From: Robin Uff [rob.uff@hotmail.co.uk]
Sent: 11 February 2013 09:12
To: Peter Jefcoate; Robin Uff; Aahsanur Rahman
Subject: 35 Sherrards Park Road, WGC- N6/2012/2652/FP

Conservation area.

PROJECT	35 Sherrards Park Road
DRAWING TITLE	Proposed Elevations REVISION D
STATUS	Pre - Planning
SCALE 1:100 @ A3	DRAWN BY AM 08 - 004PD

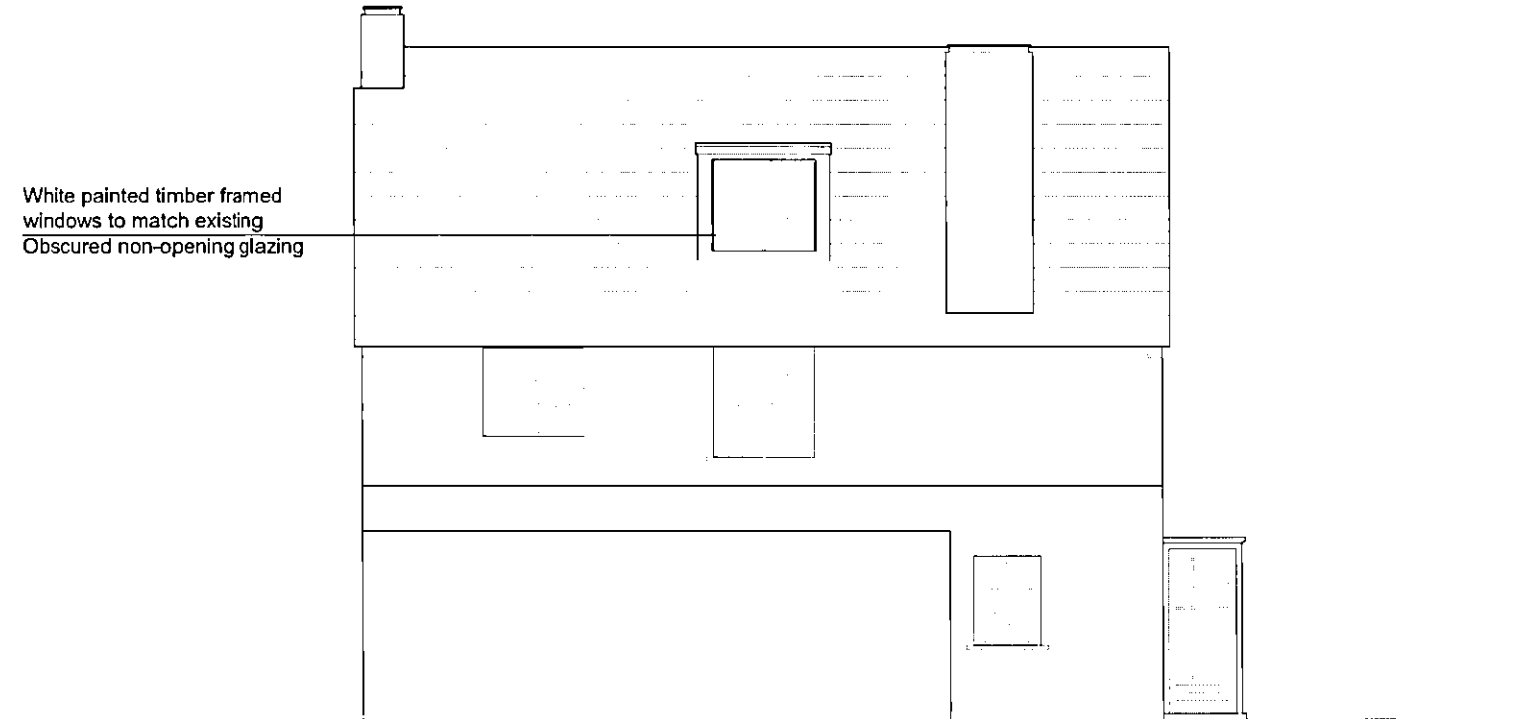
I refer to your e-mail adted 6 February. The scale, proportions & form of this proposed **dormer window** has been the subject of considerable discussion. I have some photographs if that would be useful.

The general advice to the agent has been to slim down the dormer as far as possible, to seek to achieve a vertical emphasis (rather than being more wide rather than tall- with a somewhat squat appearance within the roof). Aligning the dormer with the width of the first floor window below seems a harmonious approach. The submitted drawings are at a small scale- the elevation of the dormer seems roughly square. Proper detailed & dimensioned drawings should be required to make this point clear & also show the edge detailing of the structure & window frames.
